Our Ref : S076158.015

File No : MP10\_0104

**RE West Circular Quay Public Domain Upgrade Works, Circular Quay /  
The Rocks (MP10\_0104)**

The City has reviewed the Environmental Assessment and notes the conceptual nature of the proposal. The City generally supports the design concept but cannot give its full support to the proposal in its current form due to the lack of design resolution and detail relating to some key aspects of the proposal.

PRINCIPLES

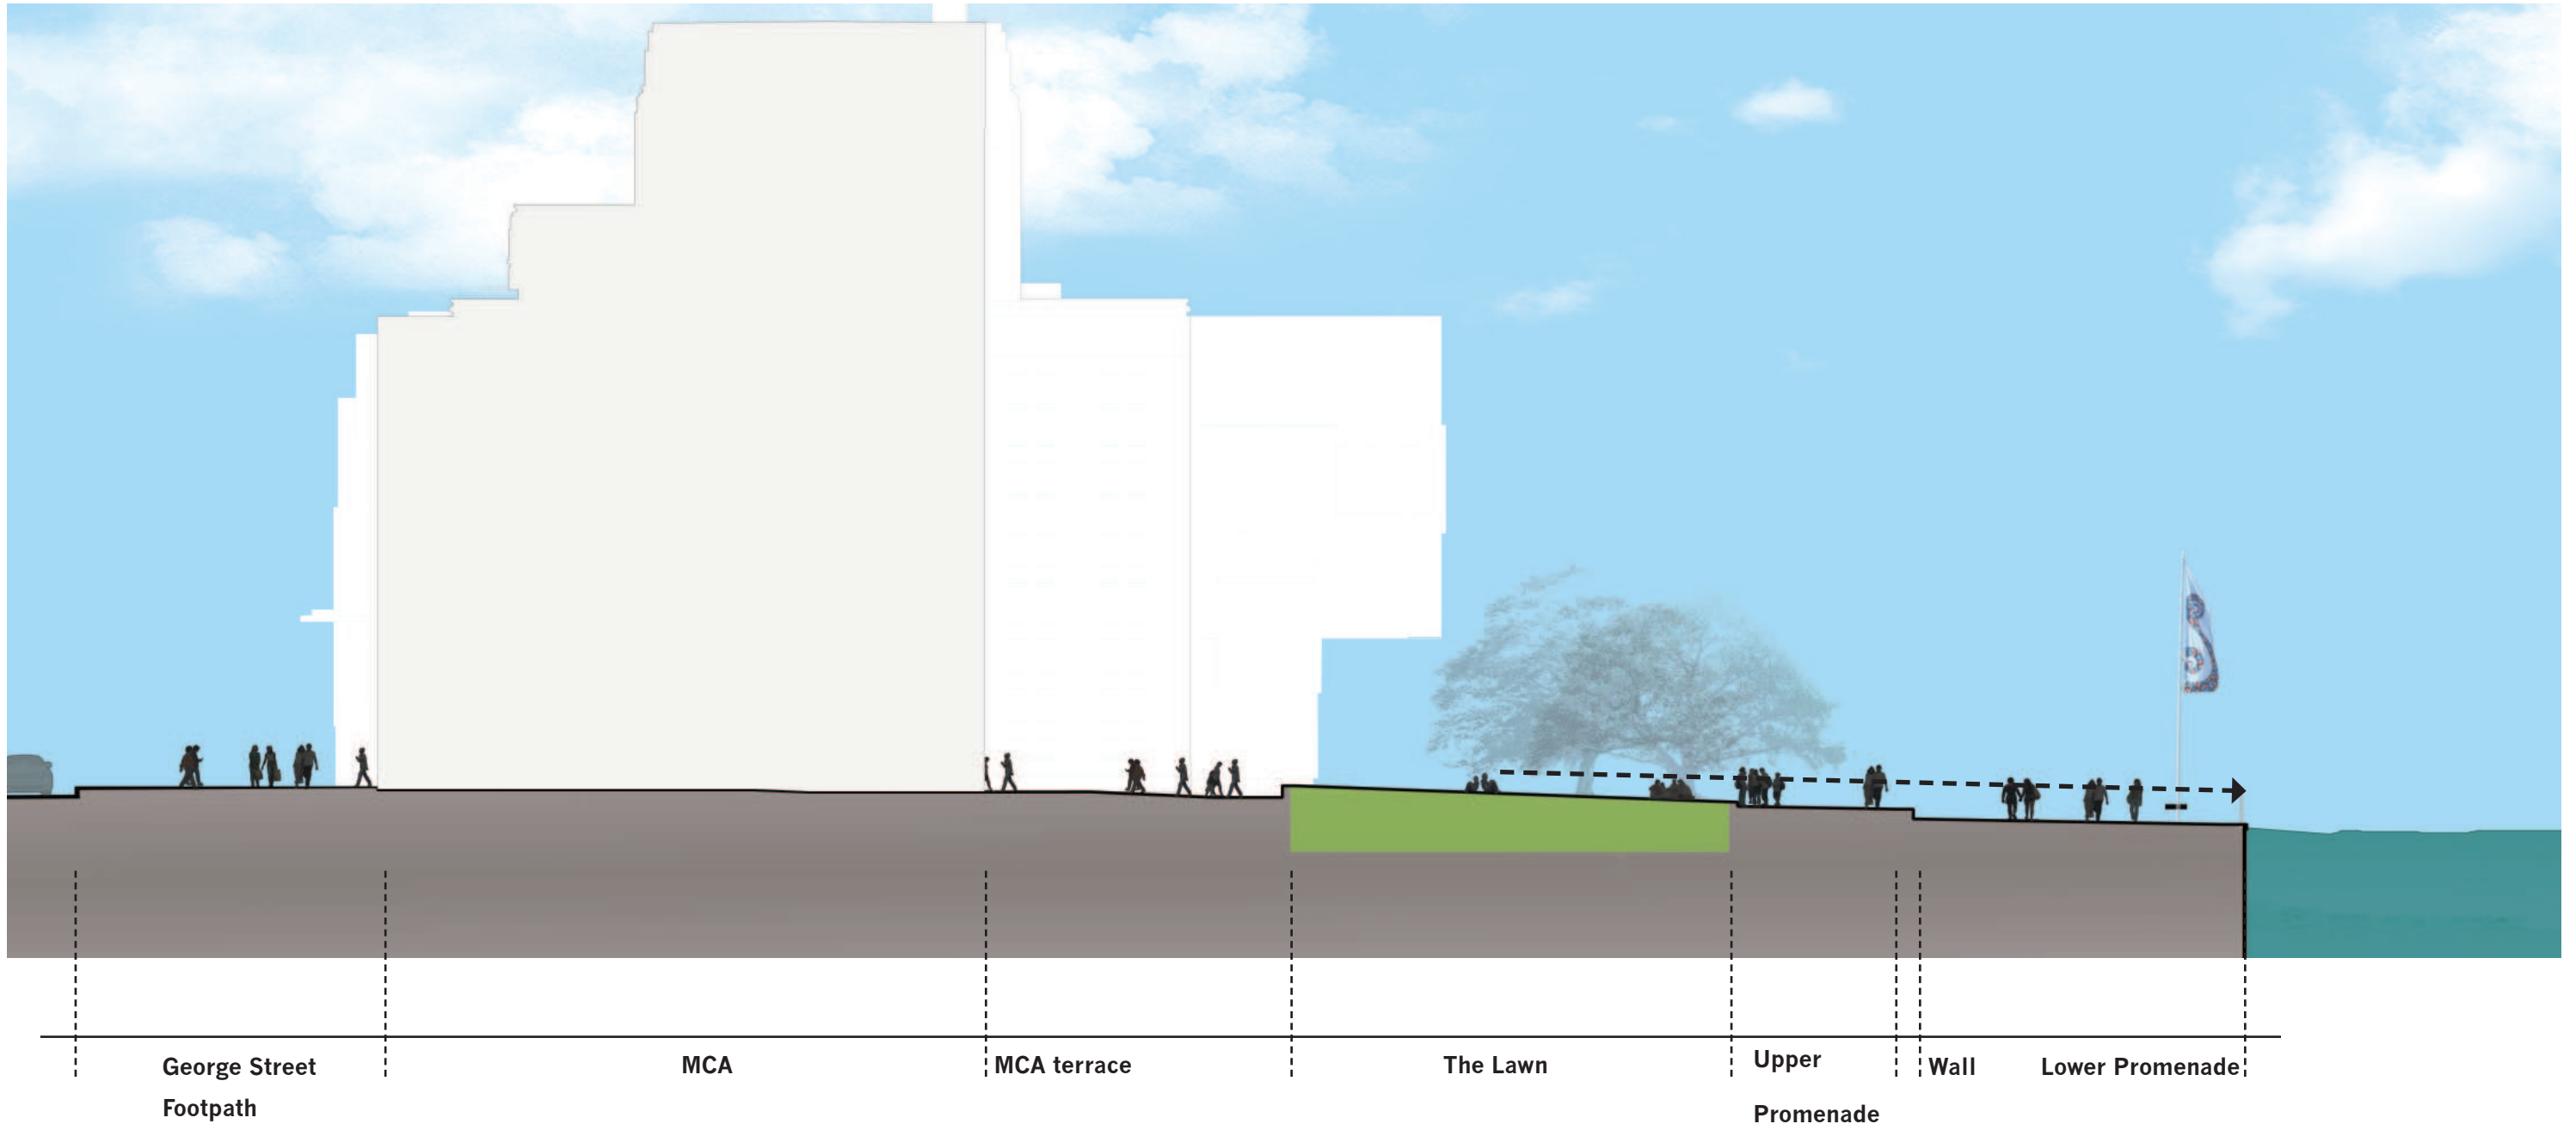
- a. The “sphere” type pole-mounted lighting design was not supported by Jørn Utzon for use around the Opera House and should not be continued.
- b. The cost of the entire lighting scheme is potentially grossly underestimated and/or inadequate and should be re-evaluated.
- c. Insufficient details are provided about the type of light fitting in “Market Wharf”.

9. Interpretation

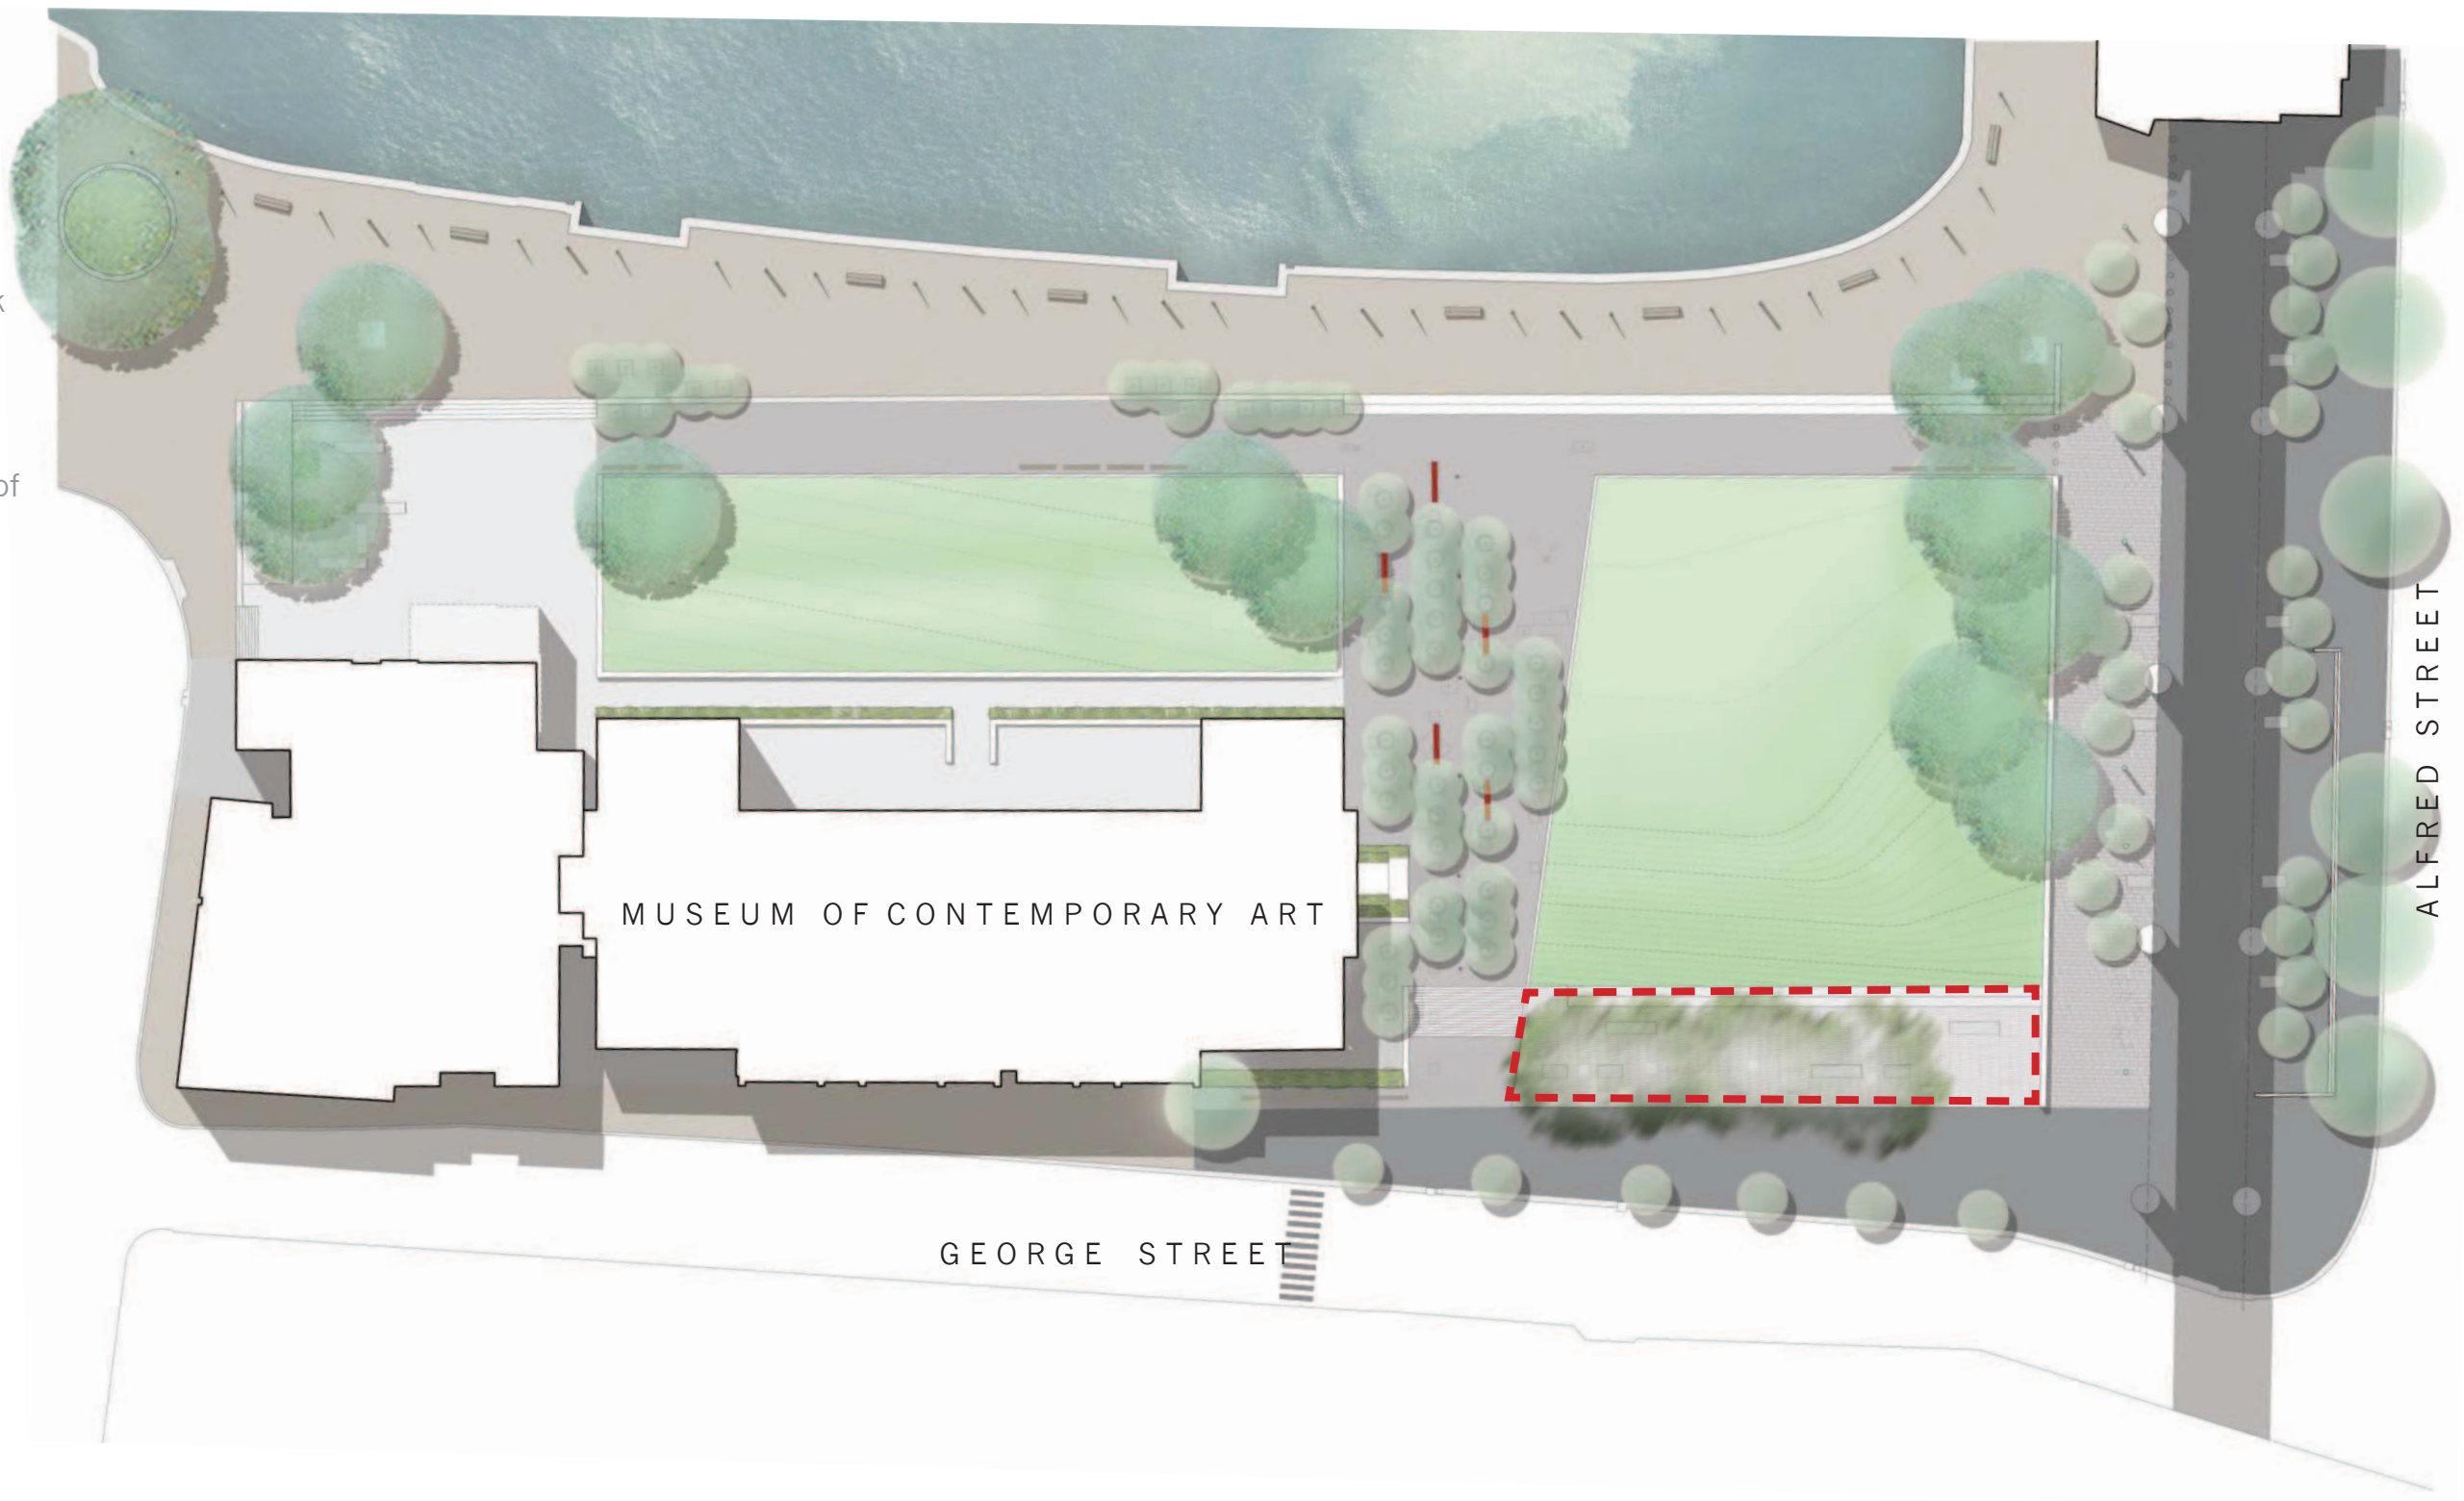
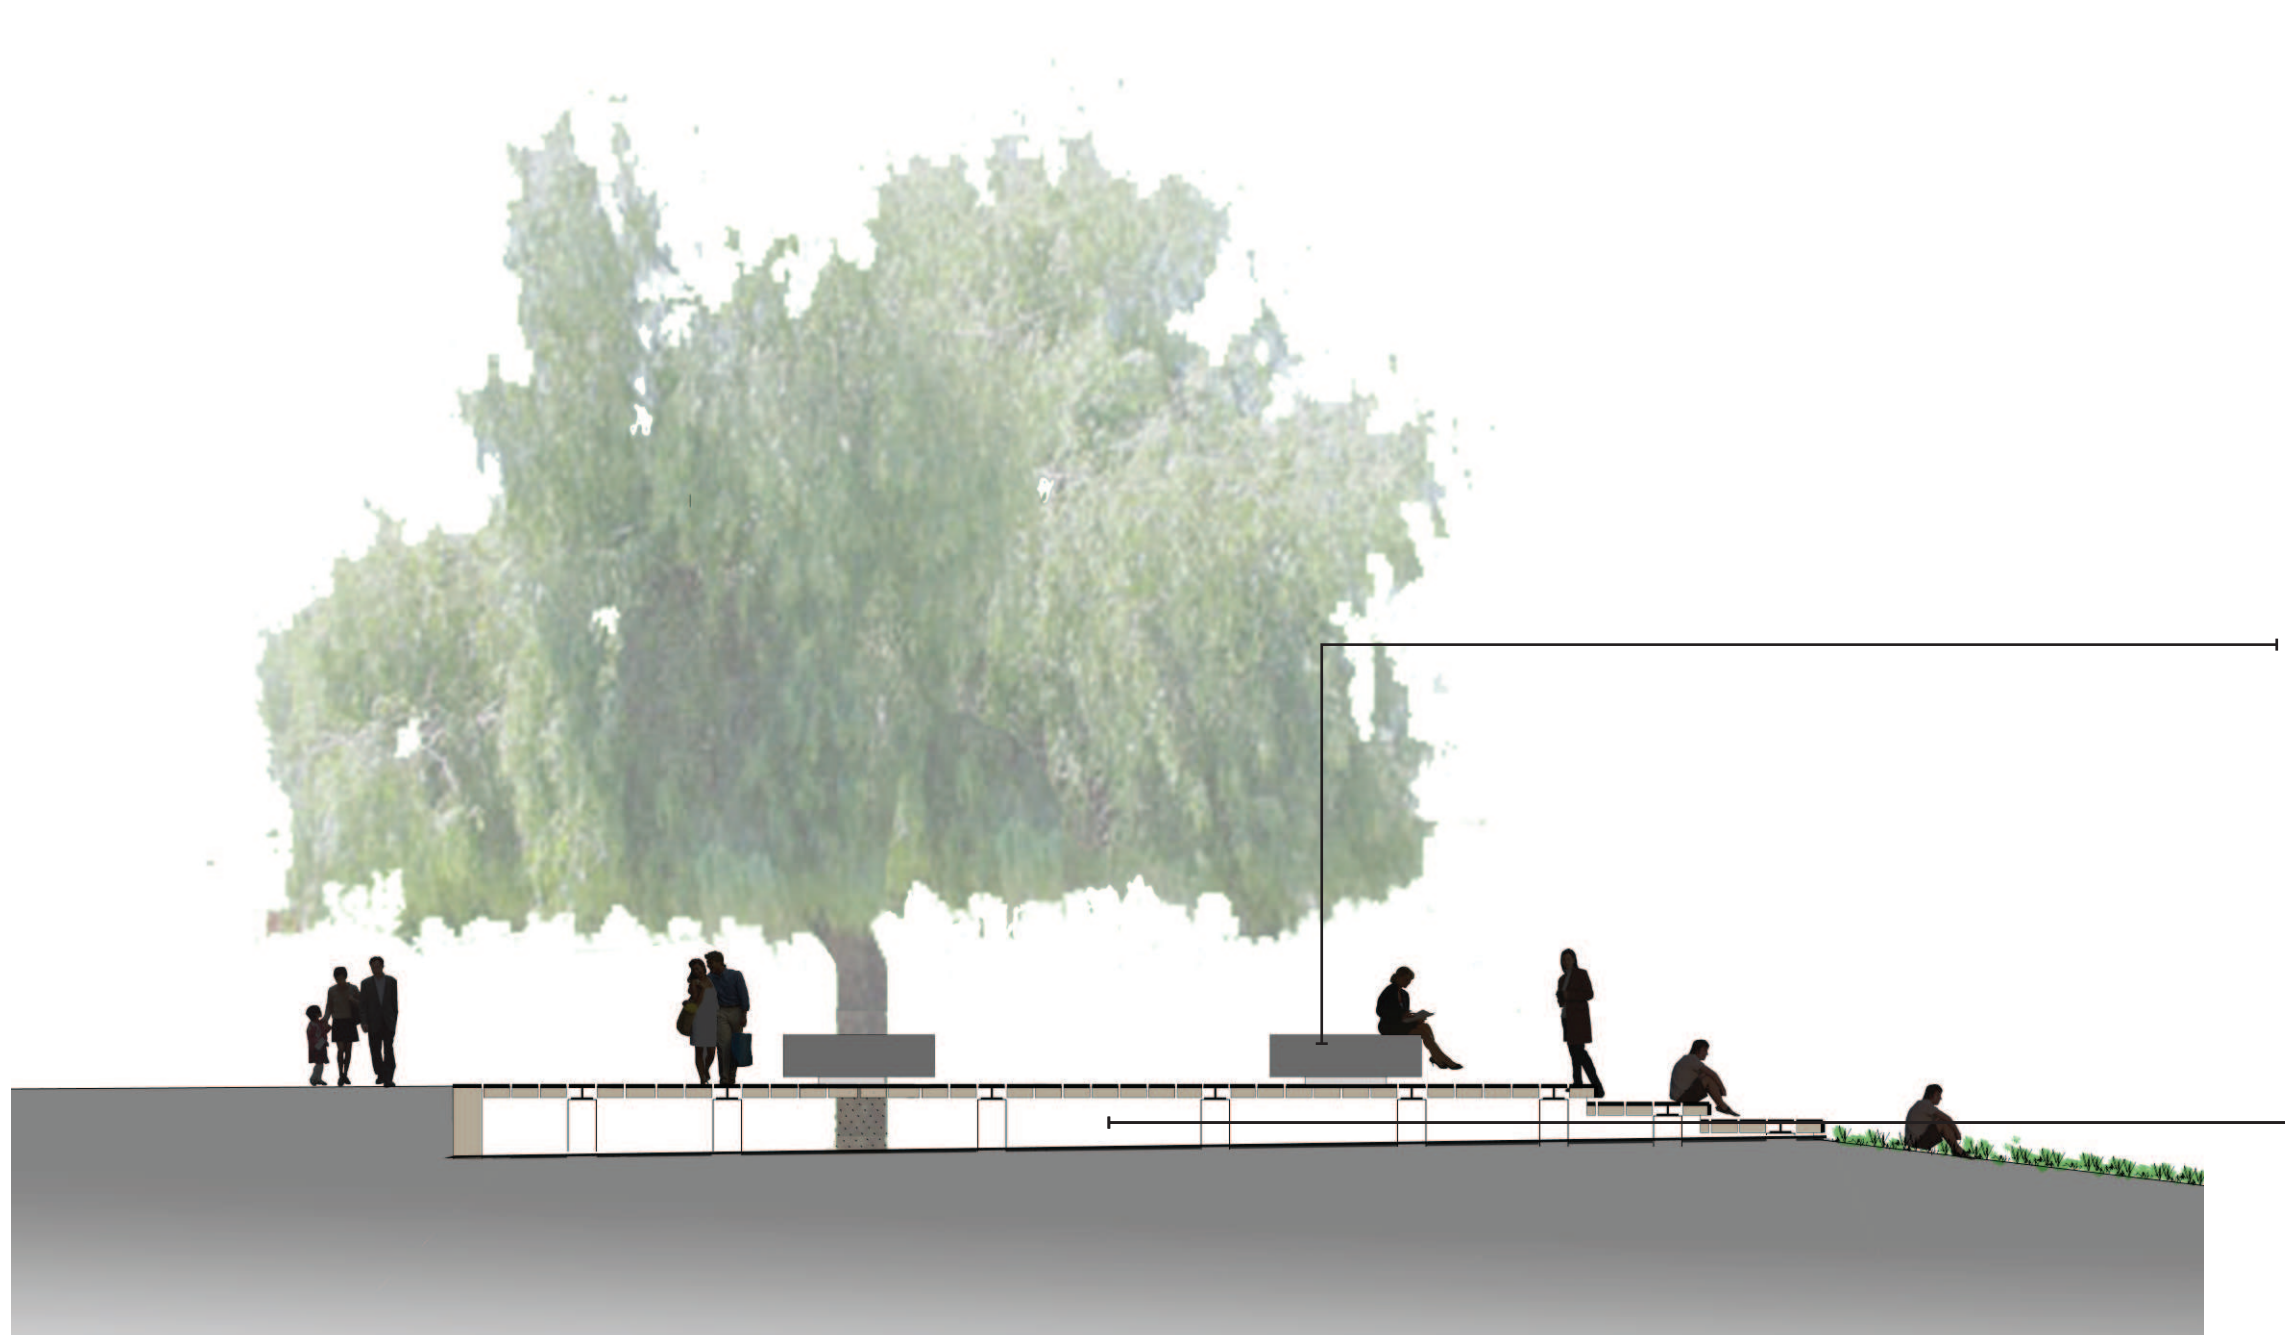
1. Heritage interpretation and public art:
  - a. The extent of heritage interpretation, consisting largely of text panels in the "The Lookout", is considered to be inadequate and does not properly acknowledge the high heritage significance of the site and the richness of its history.
  - b. The proposal does not adequately address public art opportunities, particularly its potential integration with meaningful heritage interpretation.
